Hassell © December, 2021

AGENDA Response to feedback

AMRF - First Building

ARTISTS IMPRESSION - DRY CREEK BED

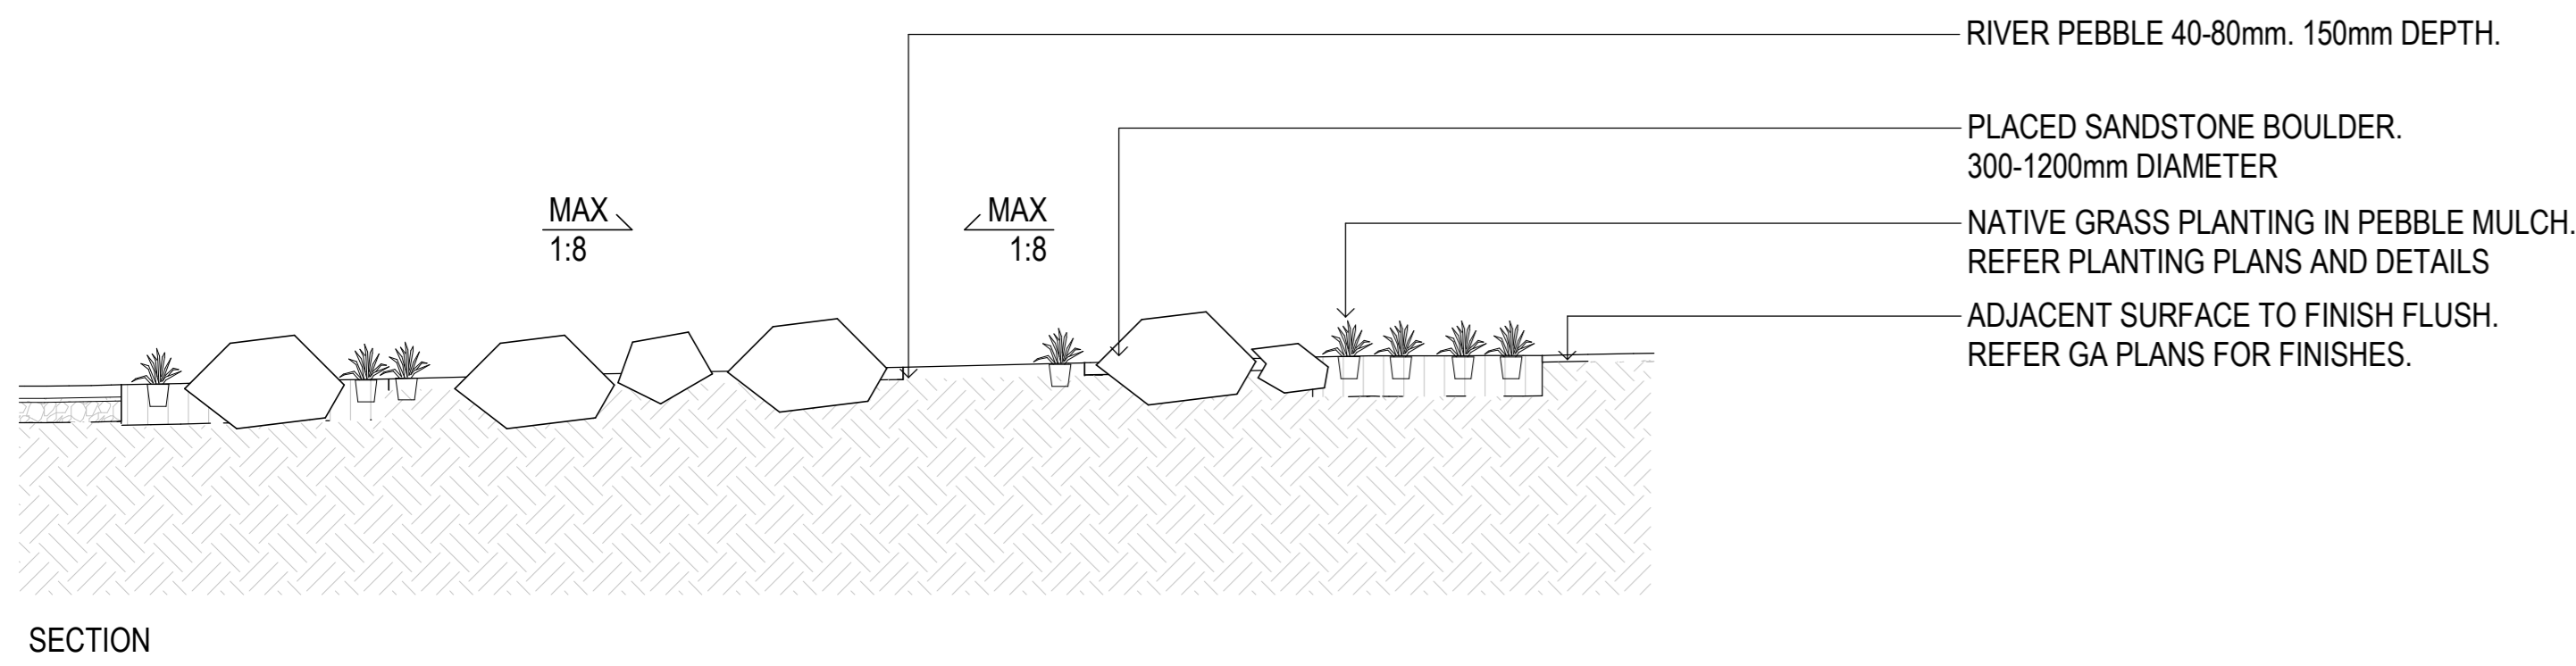
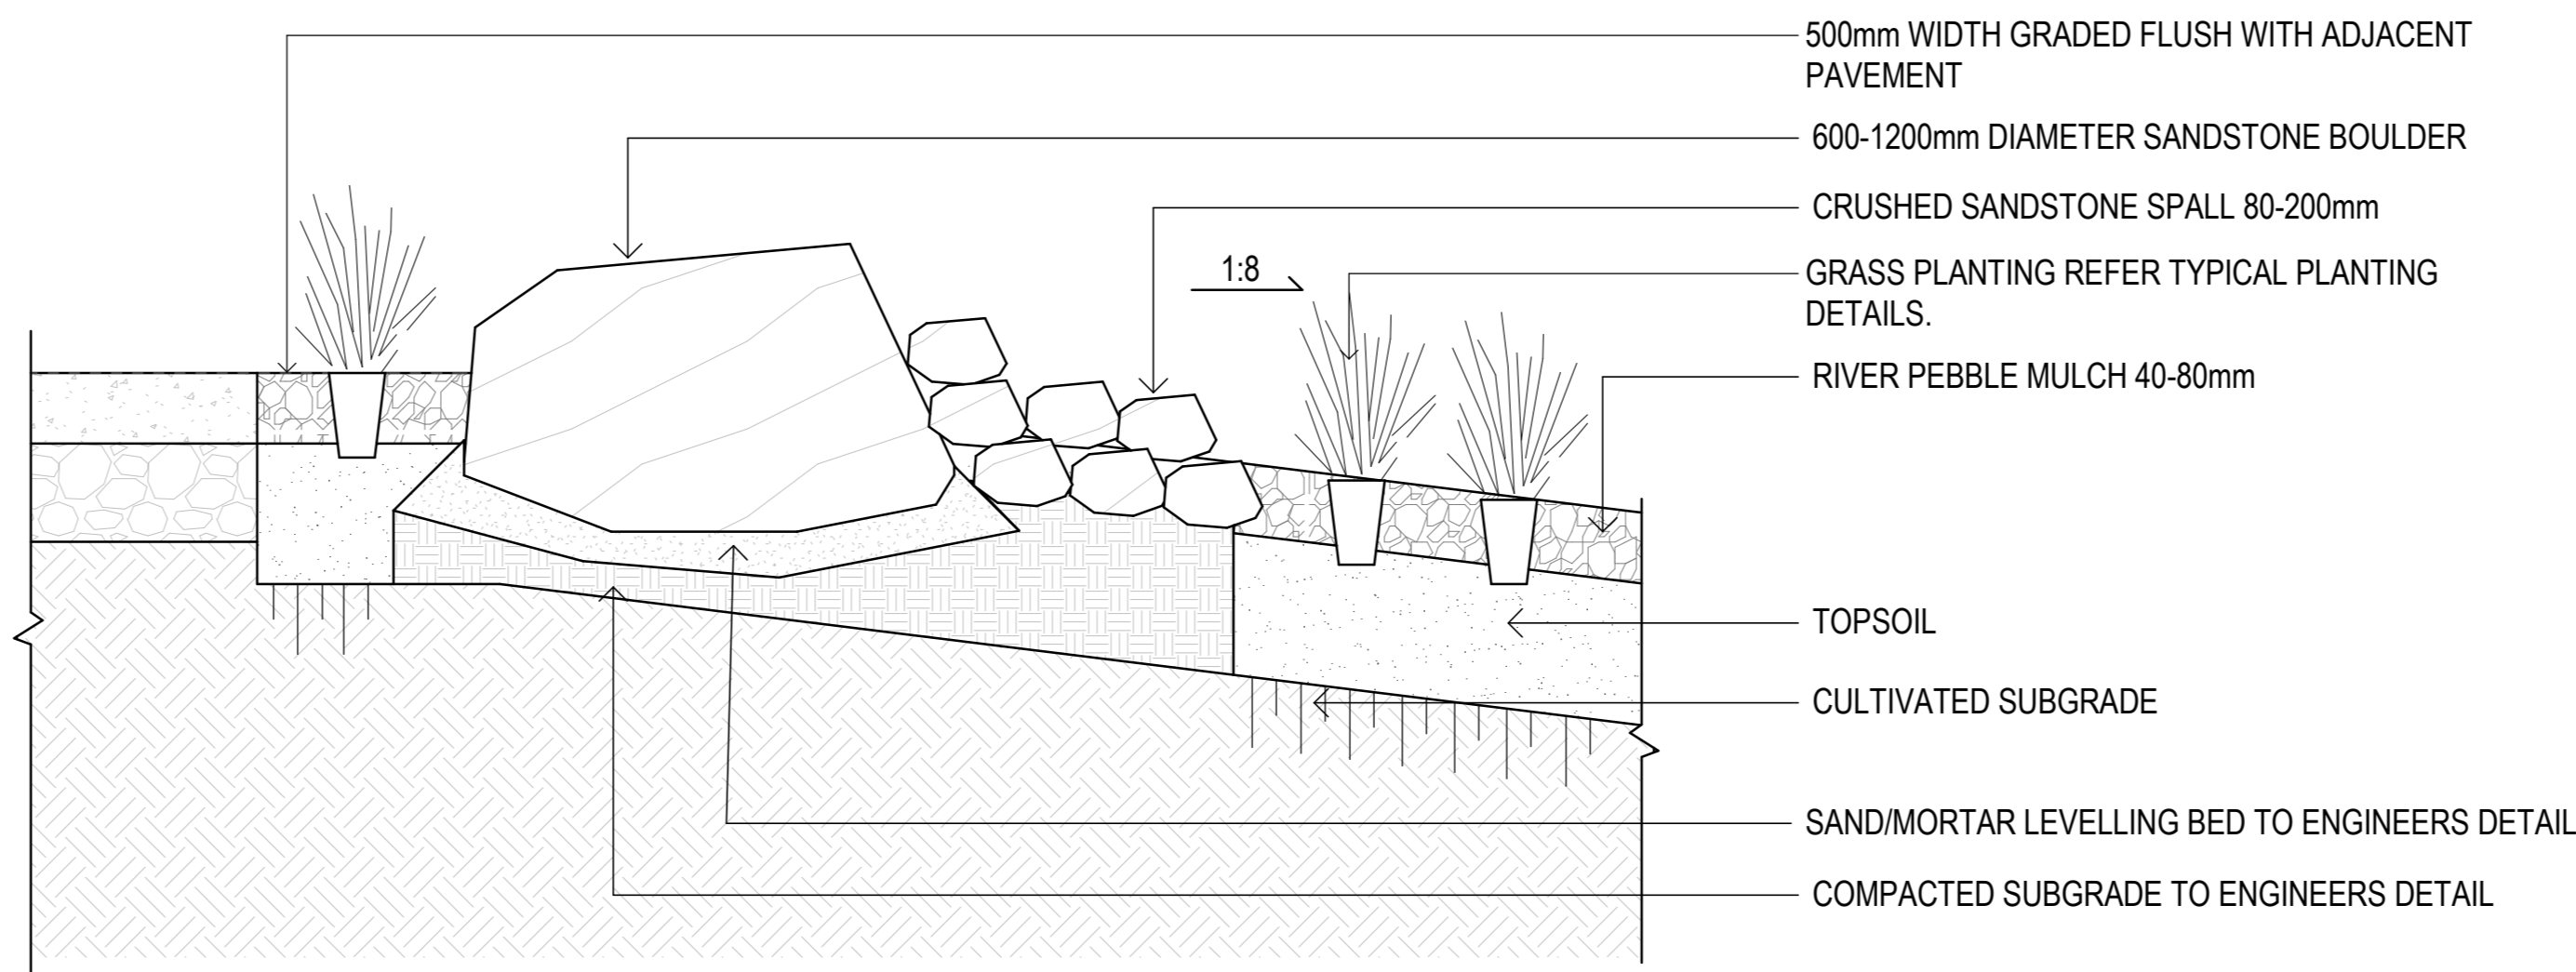
*Strengthen how the water story is reflected in the landscape design. Consider extending the water element into the building.

Rather than bury the collection and movement of water, these systems will be expressed and celebrated in the landscape through a series of small wetland, dry/wet basins, artistic treatments and swales.

1 Tree Planting
1:10

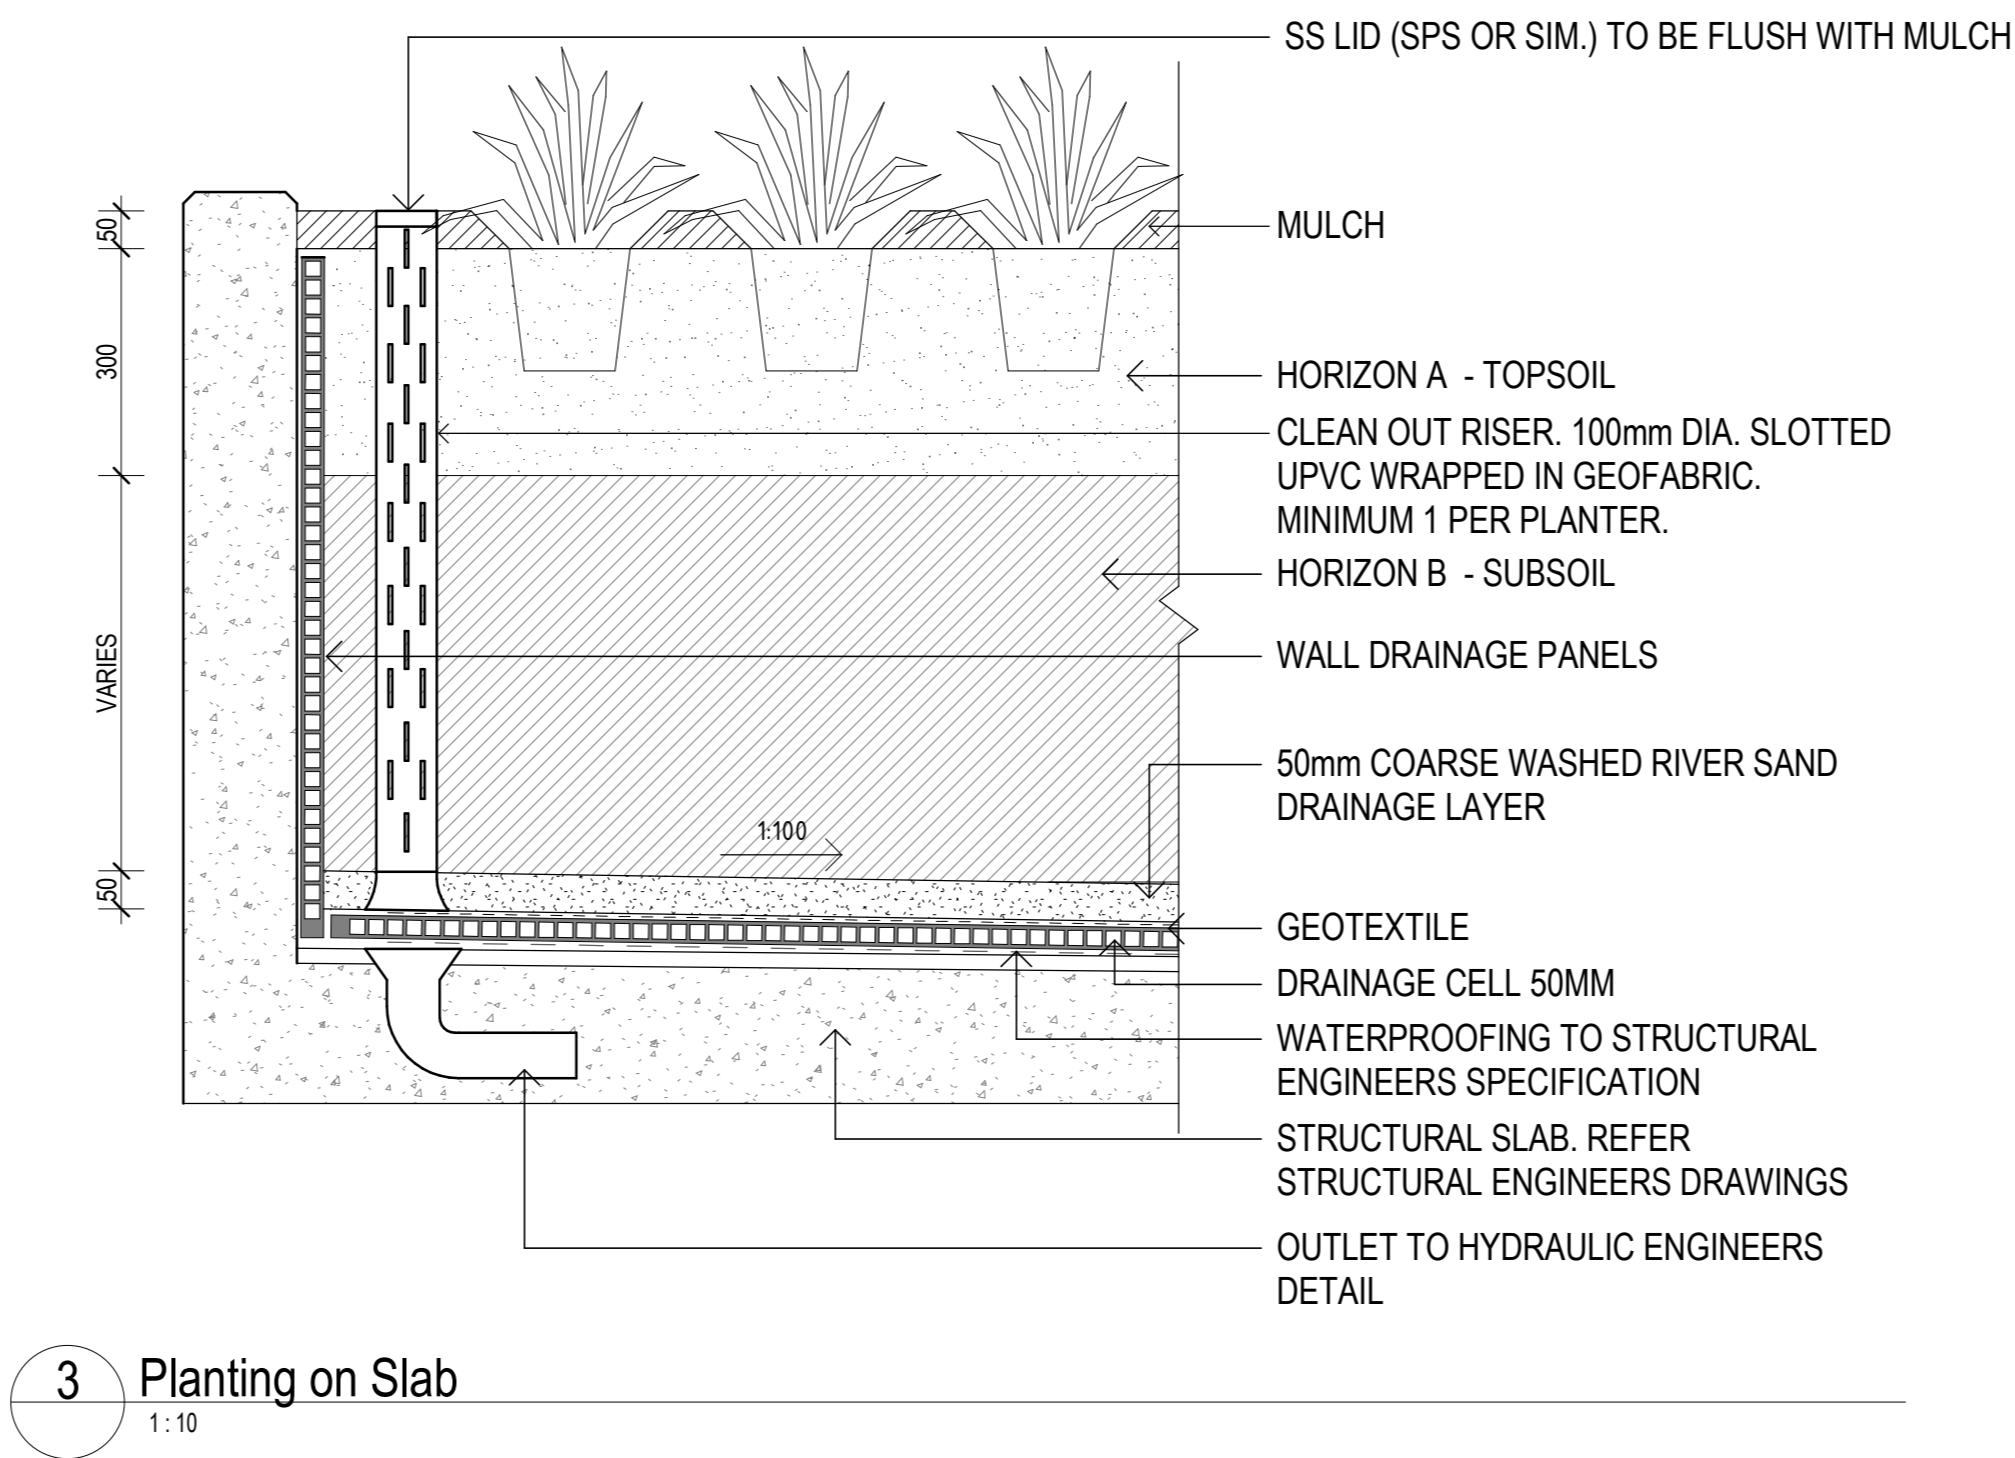
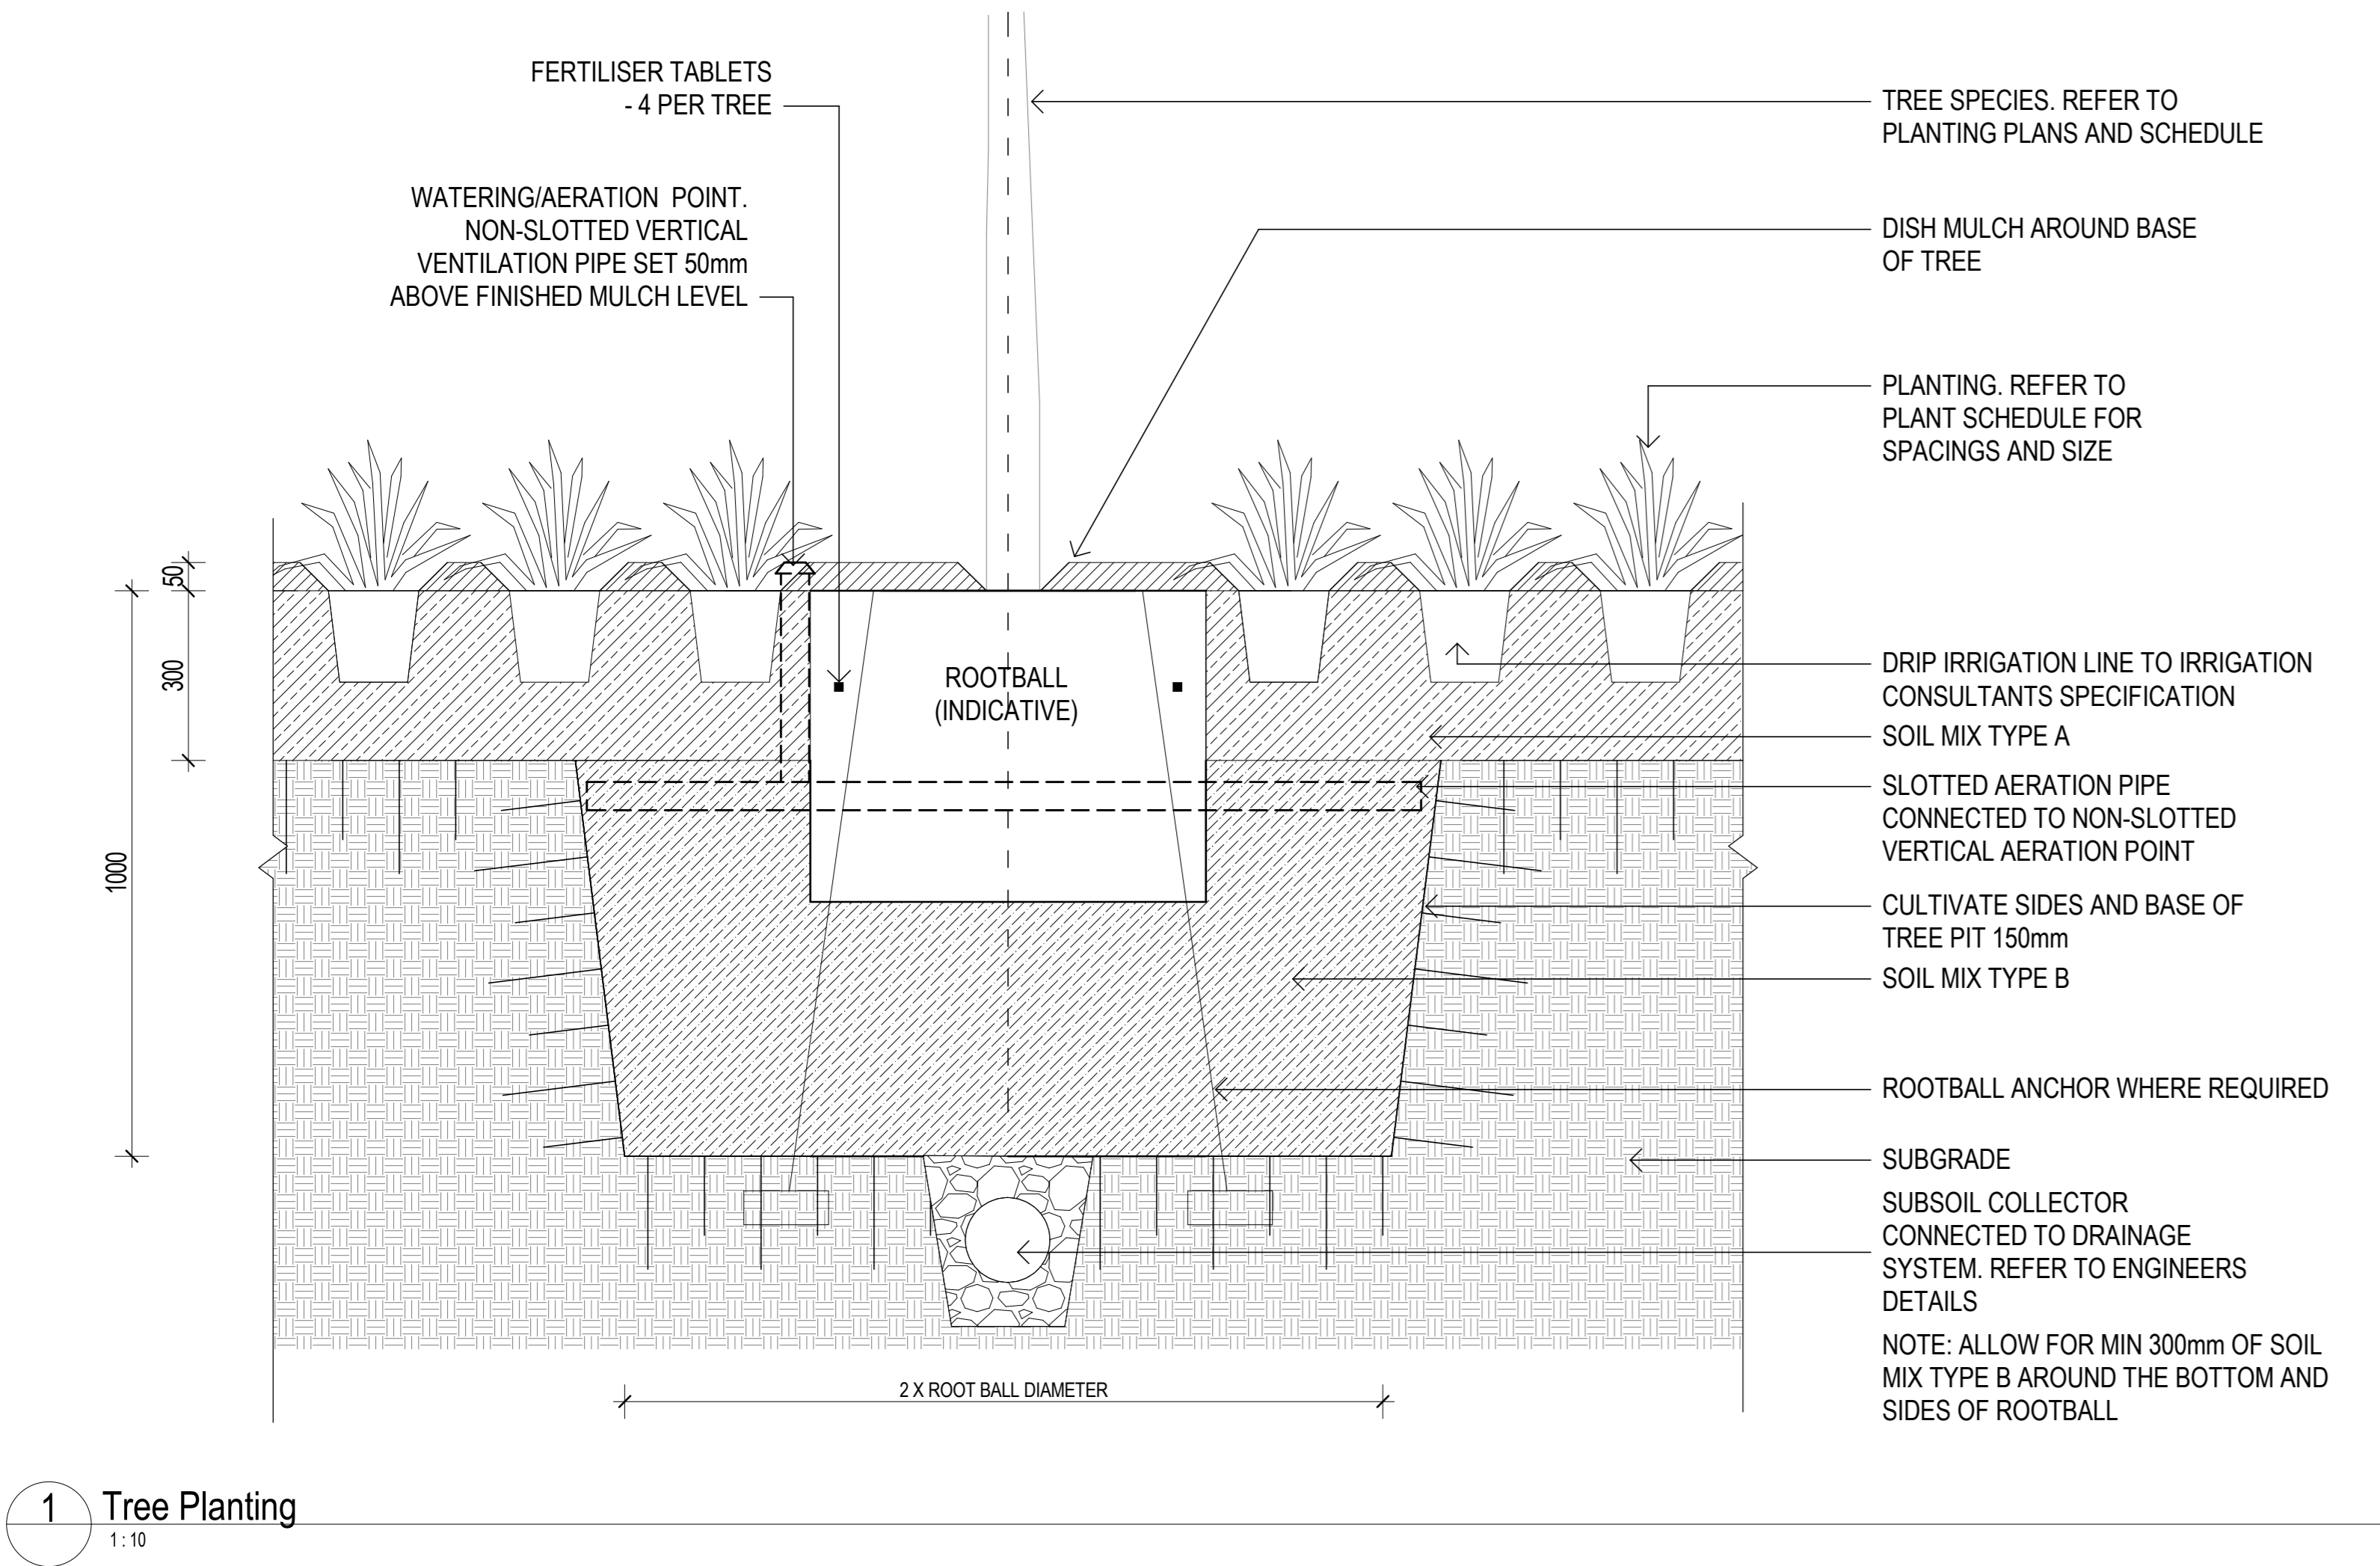
*Develop a robust planting strategy demonstrating contribution to tree canopy targets and strategies to foster native fauna (e.g. butterflies, reptiles).

The planting strategy for the AMRF First Building will utilise advanced horticultural techniques to create a highly diverse, highly floral native landscape. A combination of planting and seeding strategies for permanent and temporary landscape areas will be used.
